Recommendation Report for Planning Permission for Works or Extension to a Dwelling

REF NO: AW/424/21/HH

LOCATION: 32 Apple Grove
Aldwick
PO21 4NB

PROPOSAL: Front and rear dormer extension.

Proposed North Elevation

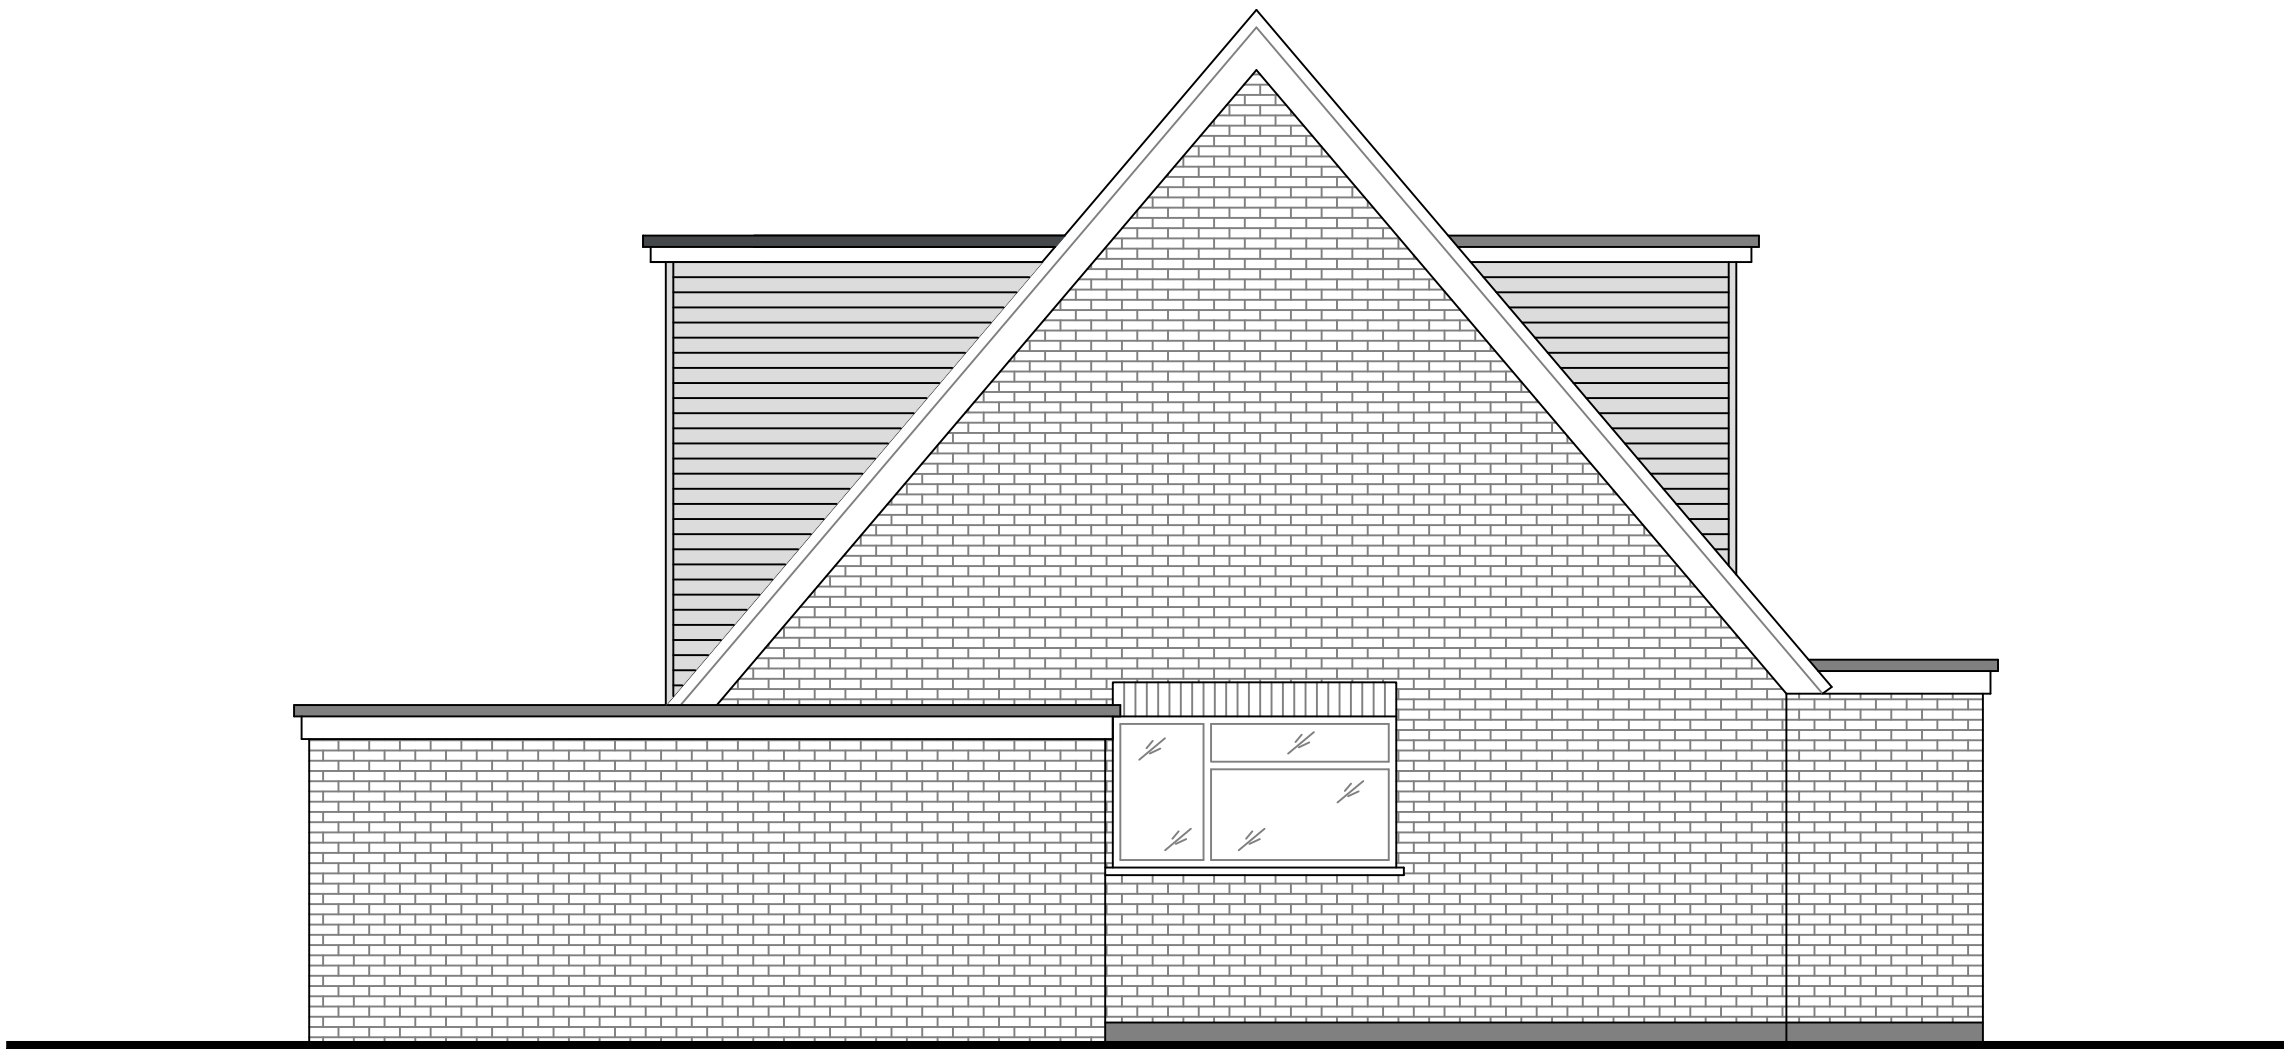
The host dwelling has existing front and rear dormers and the proposal seeks to enlarge them. To the front there are currently two individual flat roof dormers and it is intended to join them so they run along the full roof slope.

There are many other examples of dormers within the street scene and the proposal will not result in the dwelling appearing out of keeping with the area, with the scale of the dormers similar to those in the surrounding area. Whilst the front dormer will occupy more of the roof slope, the dormers retain sufficient space to the ridge and do not appear an unduly dominant feature.

The rear dormers are partially visible from the wider area at Regis Avenue although views are largely restricted as a result of the siting.

The Arun Design Guide states 'Dormers are located symmetrically and centrally on a roof, without being overly dominant or out of proportion and/or style to the original structure' and 'Favours small scale dormer windows with pitched roofs over large, flat box-shaped designs'. The proposal complies in part with the guide. The dormers are located centrally and are in proportion to the dwelling although they do feature flat roofs. This is although consistent with the design in the area.

To the rear there are two individual dormers which will be joined and enlarged. The dormer to the eastern side of the roof slope will extend in depth by around 0.75m, siting just above the eaves and meeting with the rear of an existing single storey rear extension. The dormer extension is likely to be visible from the neighbour to the eastern side at No.1 Regis Avenue however being contained within the roof slope it is not considered harm would be significant.

The dormers would allow for some overlooking upon the rear, however views are not considered to increase from that which are achieved from the existing dormers.

Proposed First Floor Plan

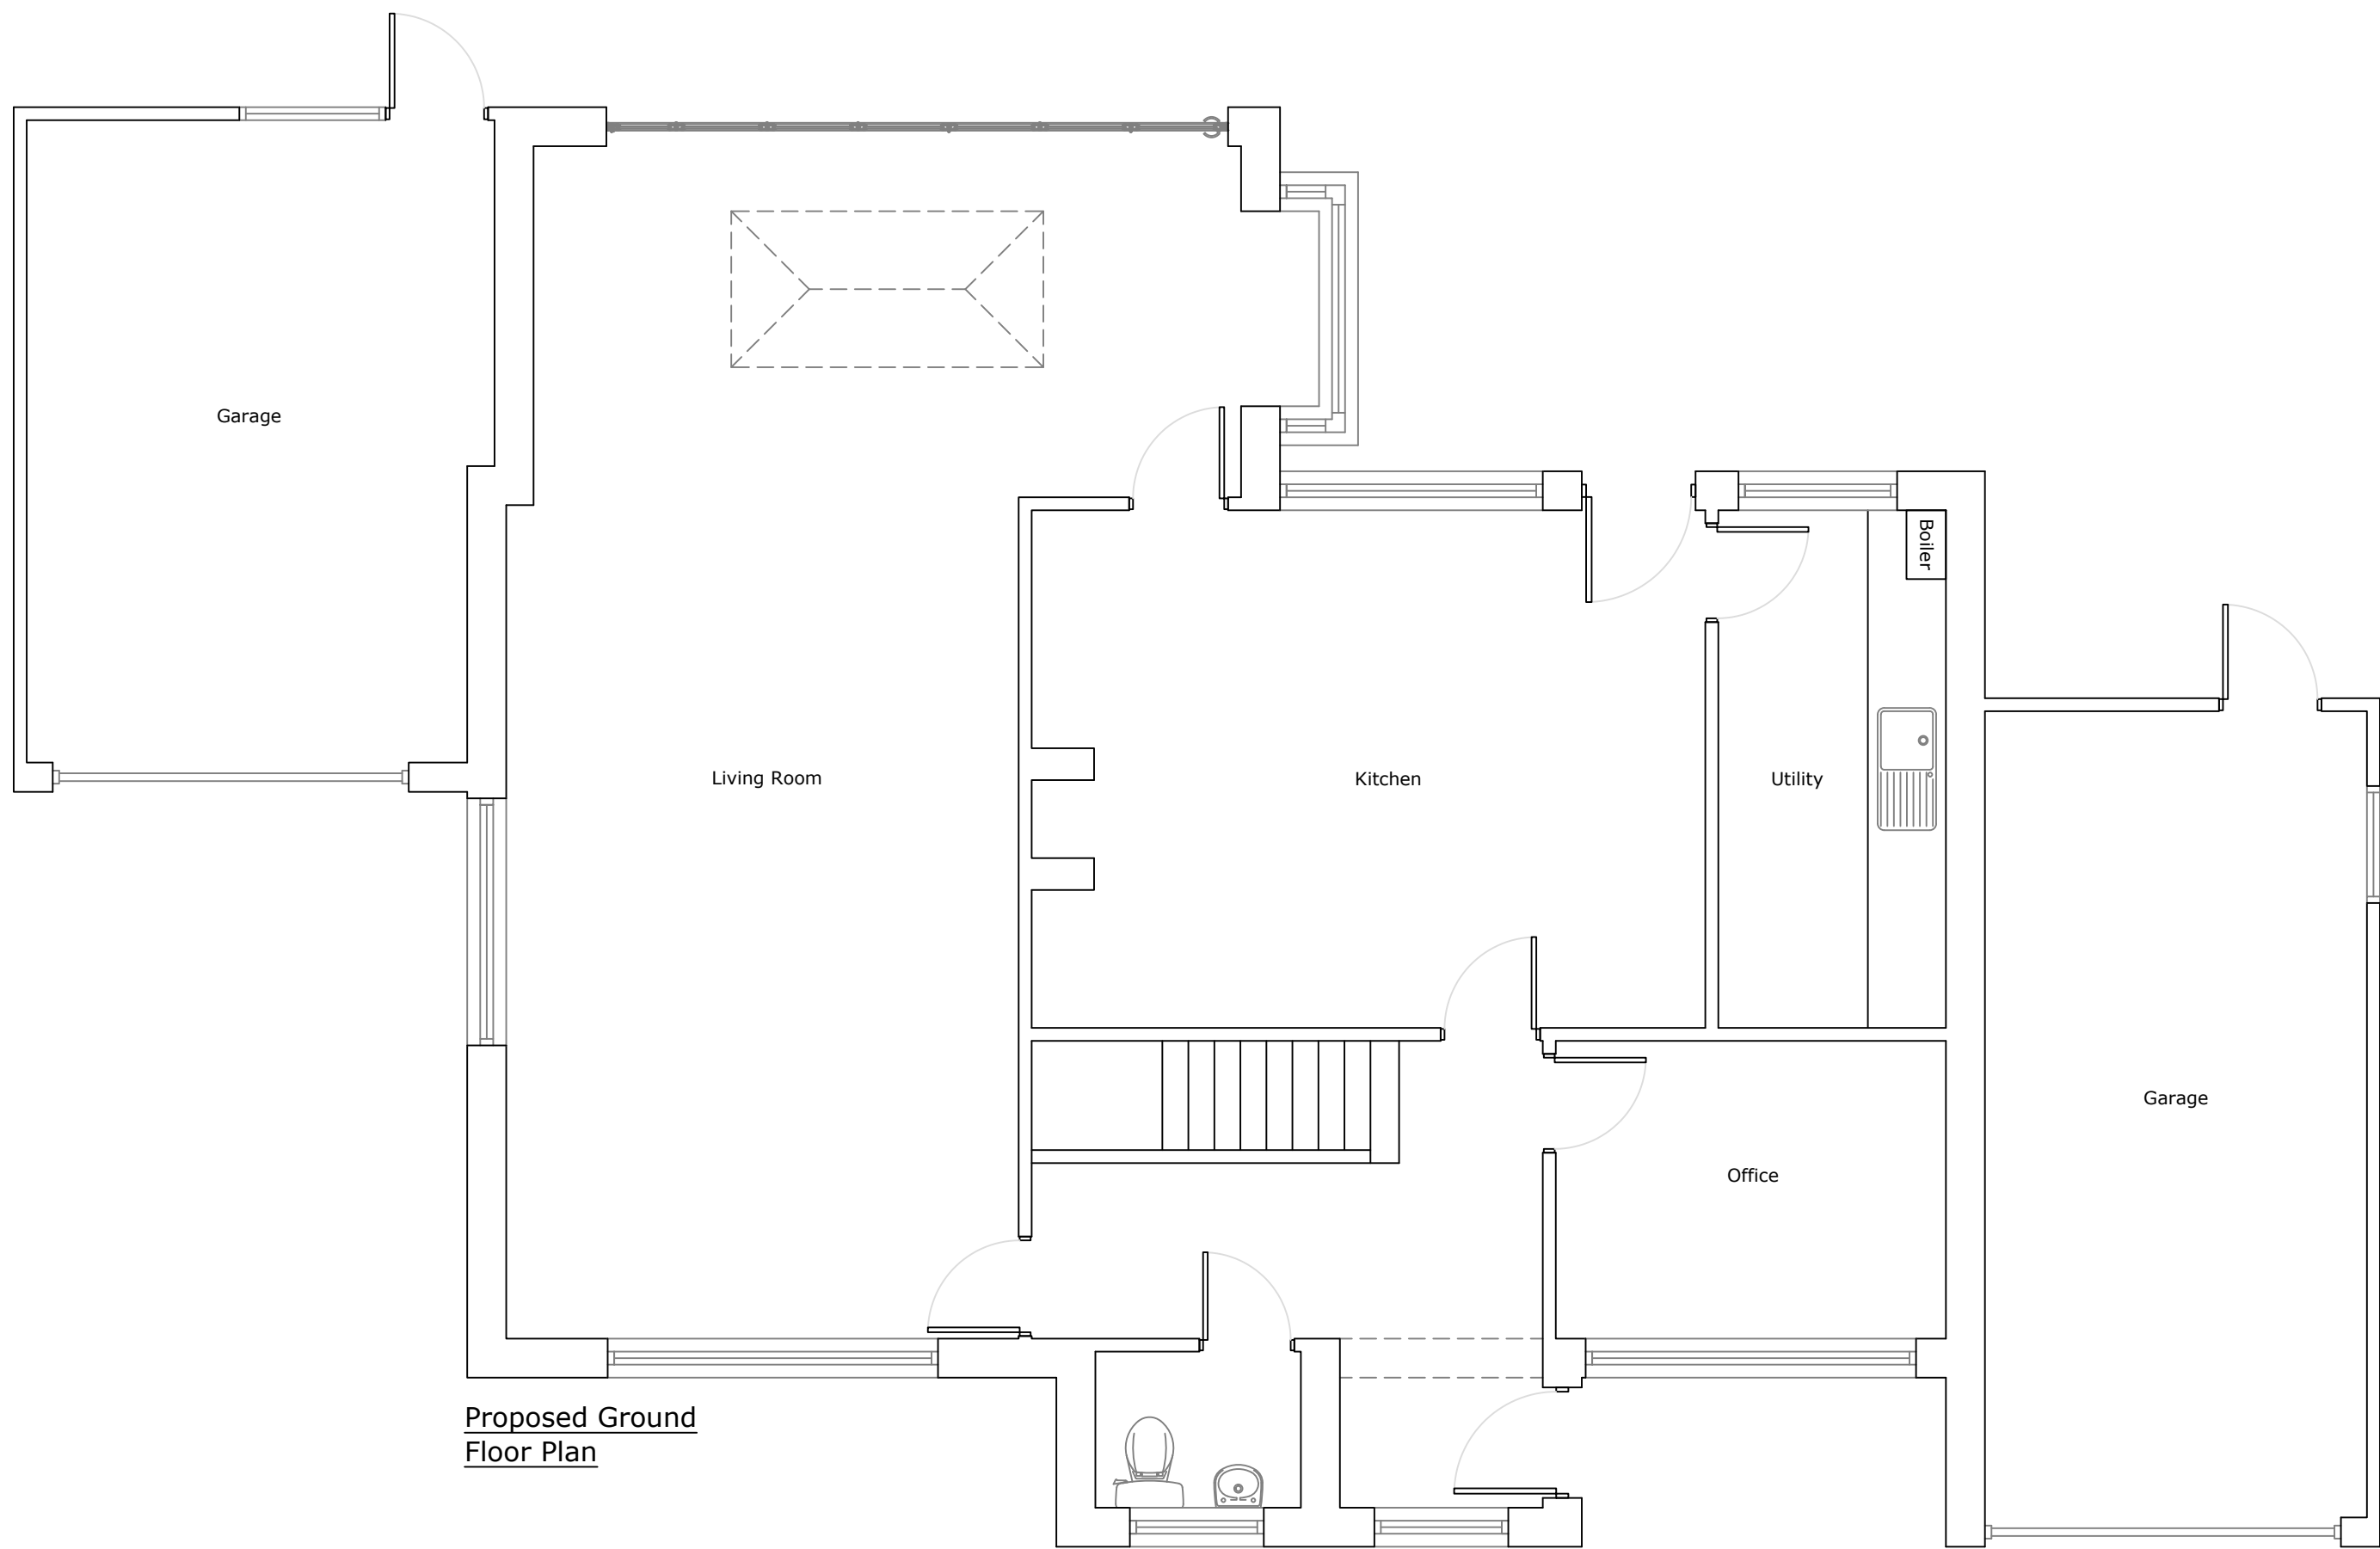
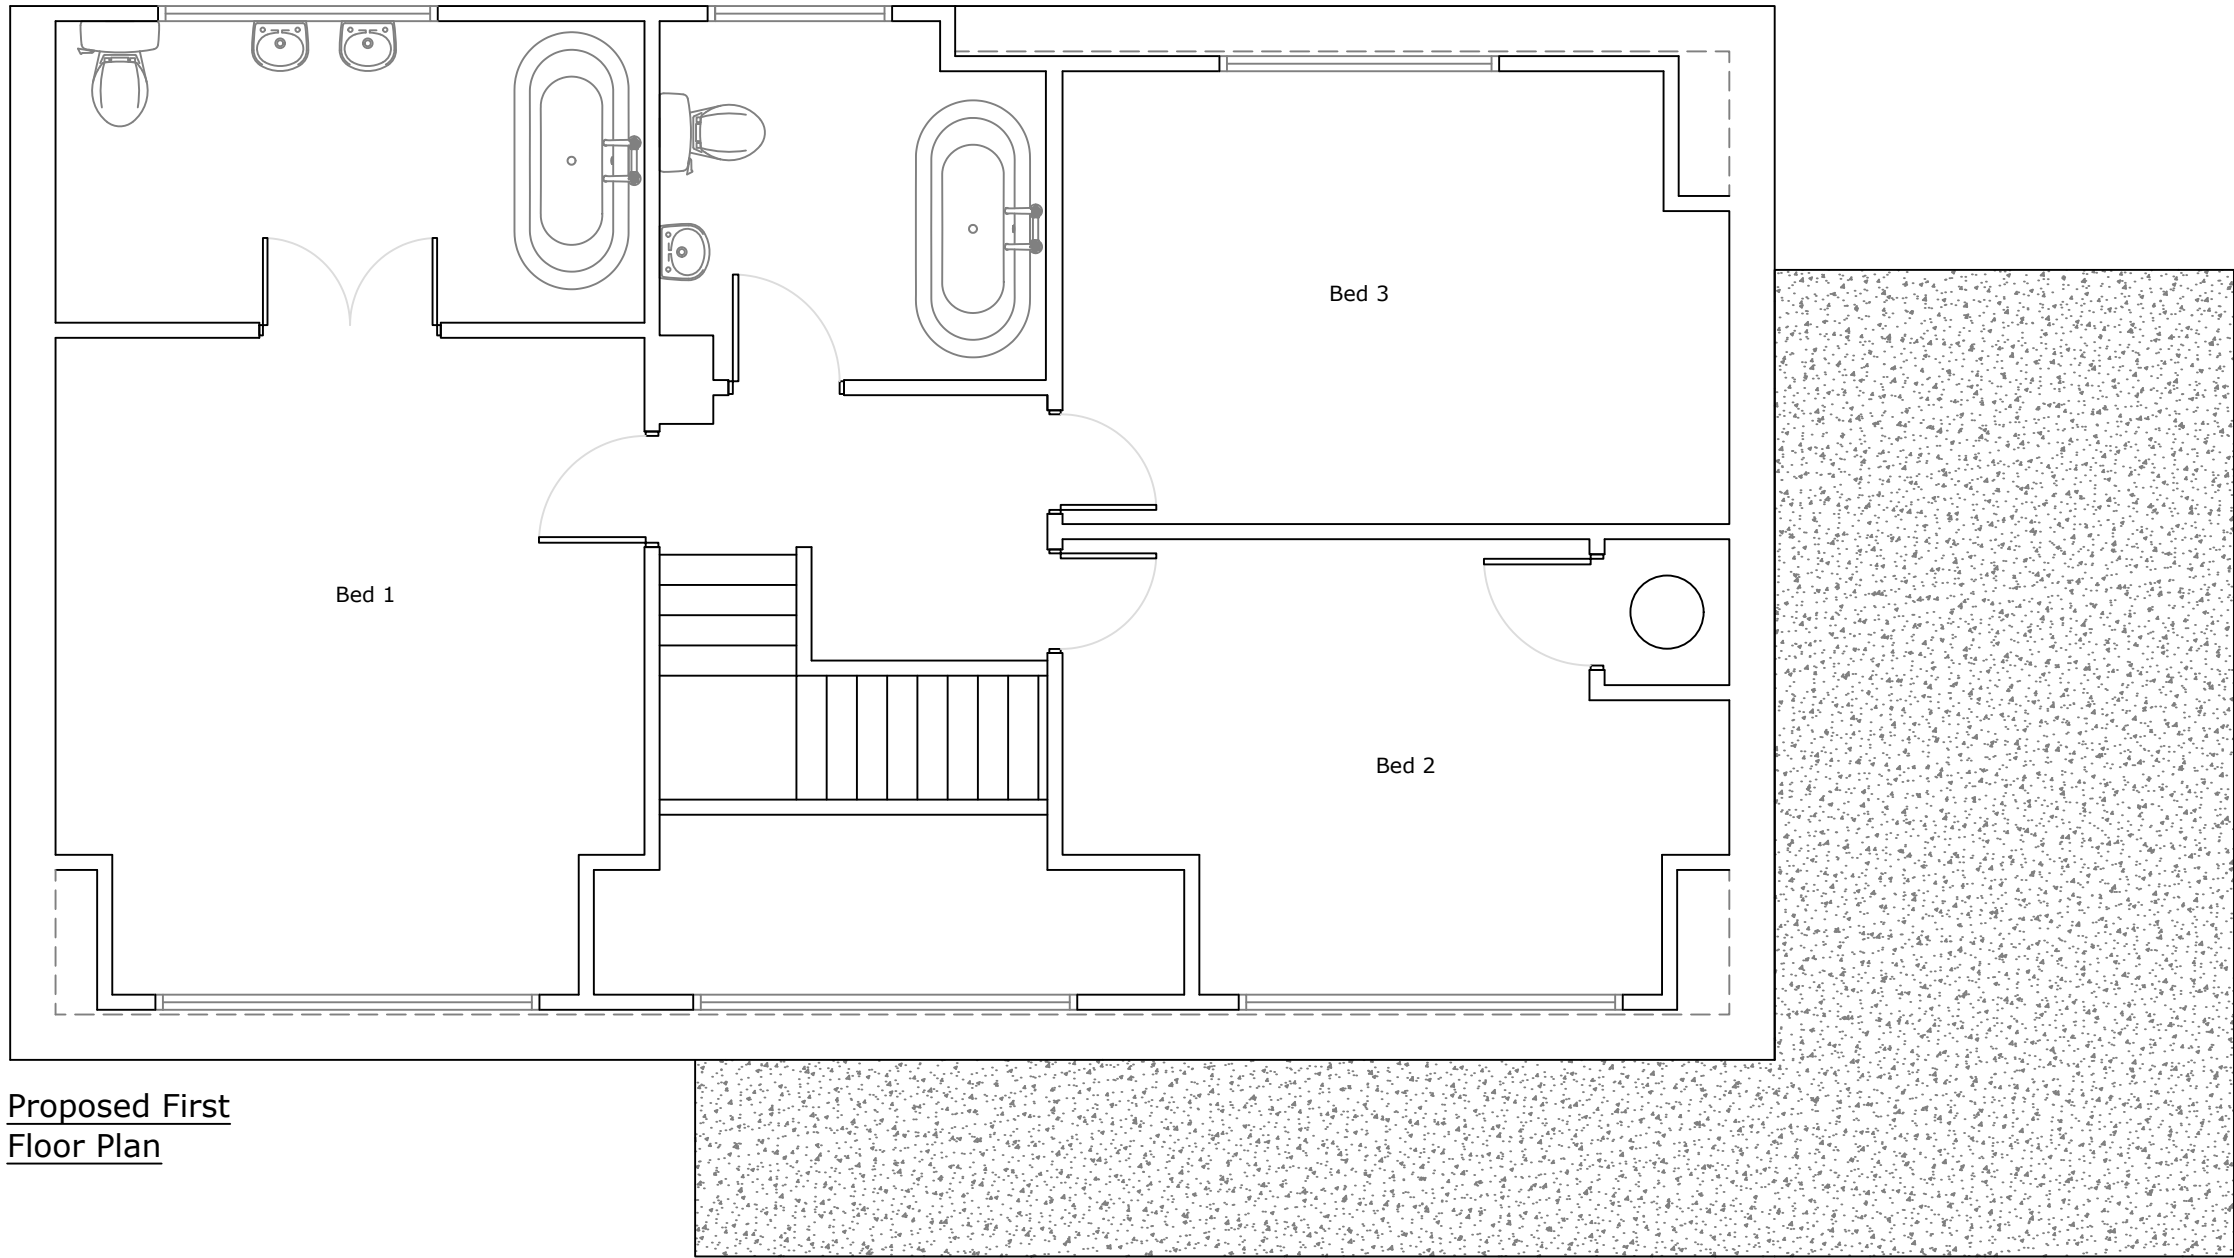
Due to the siting of the front dormers they will not result in adverse harm upon amenity by way of overbearing or overshadowing. There will be an additional window due to the increased length of the dormer although views will be over the street scene.
